Department of
Environment and Conservation (NSW)

Your reference :
Our reference : 282151A7:WOF13617:PW
Contact : Paul Wearne, (02) 4224 4100

**BLUESCOPE STEEL COGENERATION PLANT
PROPOSED SALT WATER COOLING**

DEC COMMENTS ON REPORTS SUBMITTED TO DATE

Bottom Layer

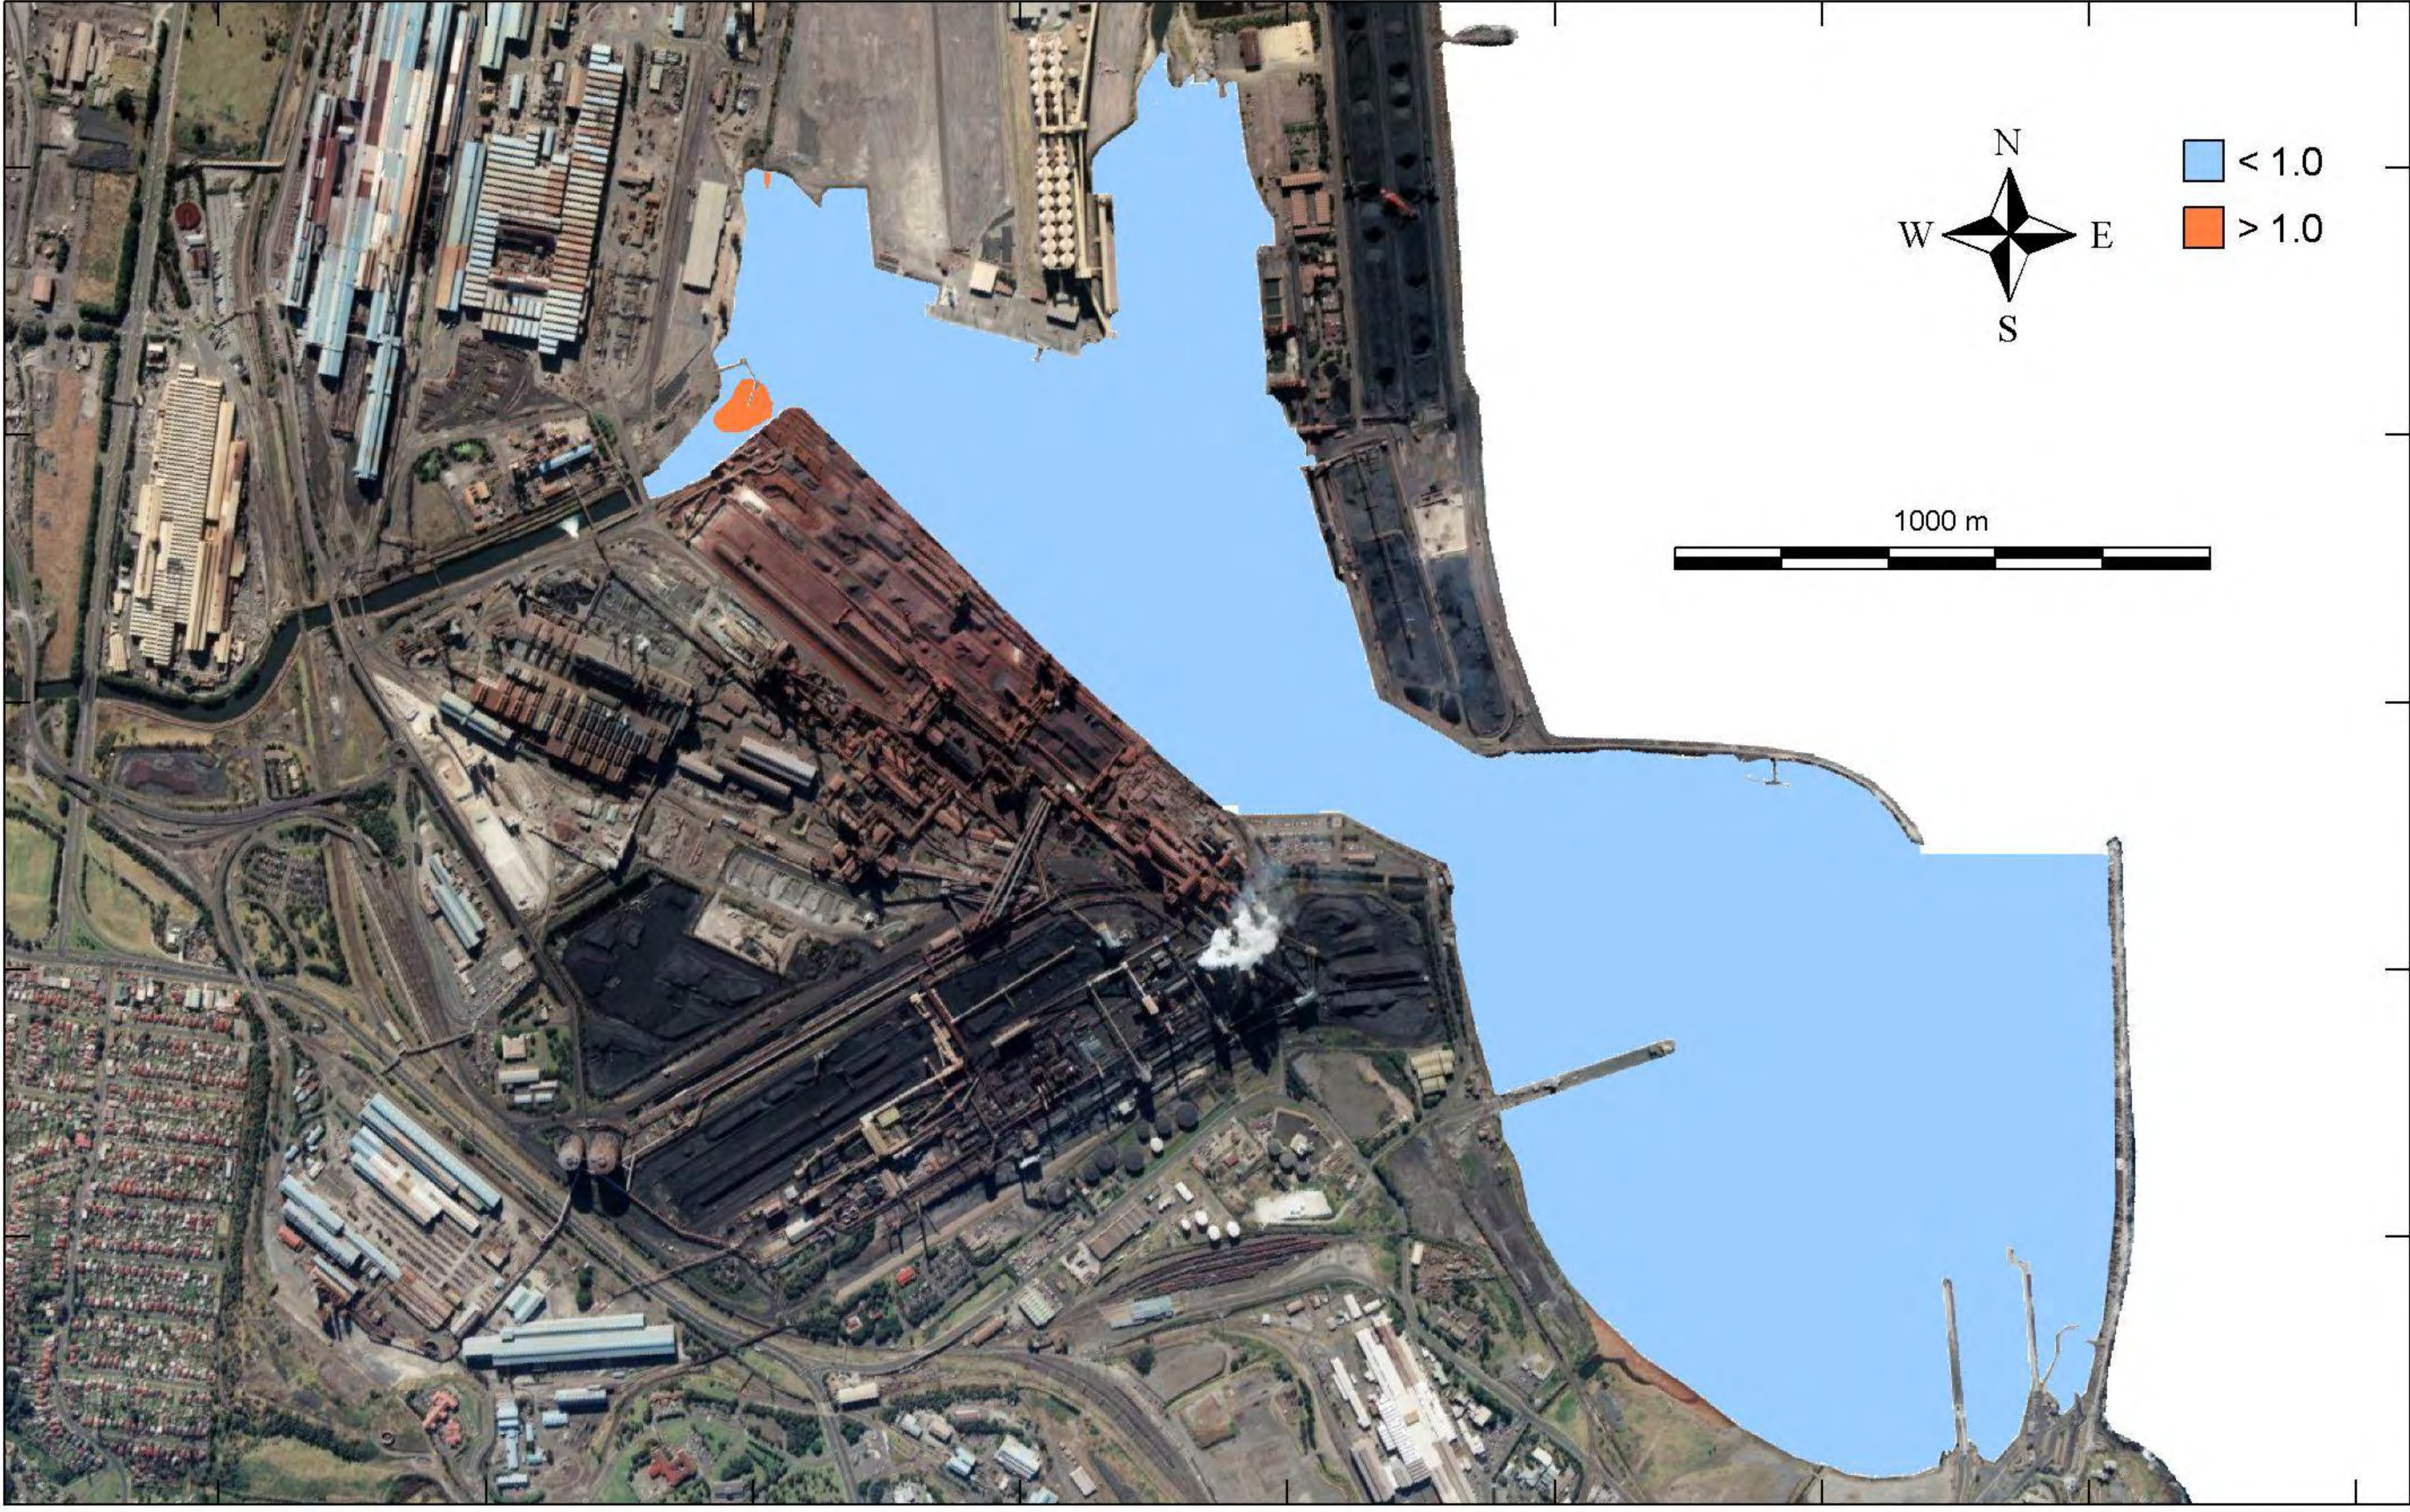
Model scenarios should describe a set of worst case conditions (from an environmental perspective) as well as typical conditions. Modelling investigations must, therefore, include simulation of average daily and maximum heat loads for all seasons including winter when temperature increases may be greatest due to cooler receiving waters (existing modelling focused on the period from 1st Jan to 28th Feb when the heat load is expected to be greatest).

Results of modelling scenarios should also be presented as differences between water temperatures with and without the thermal loading in order to illustrate the extent of the thermal disturbance above ANZECC (2000) trigger criteria. That is, the simulated 50th percentile temperatures must be compared with 80th percentile natural ambient temperatures. This analysis can be undertaken for a summer period (e.g. 1st Jan to 28th Feb) and an equivalent winter period when ambient water temperatures are at a minimum.

The adoption of 22.5°C as the boundary temperature condition must be substantiated.

It will be necessary to verify the model against observation of actual water temperatures across the modelling domain. Any existing verification data for the current discharge should be presented to validate the model which will be used for assessment of proposed discharges.
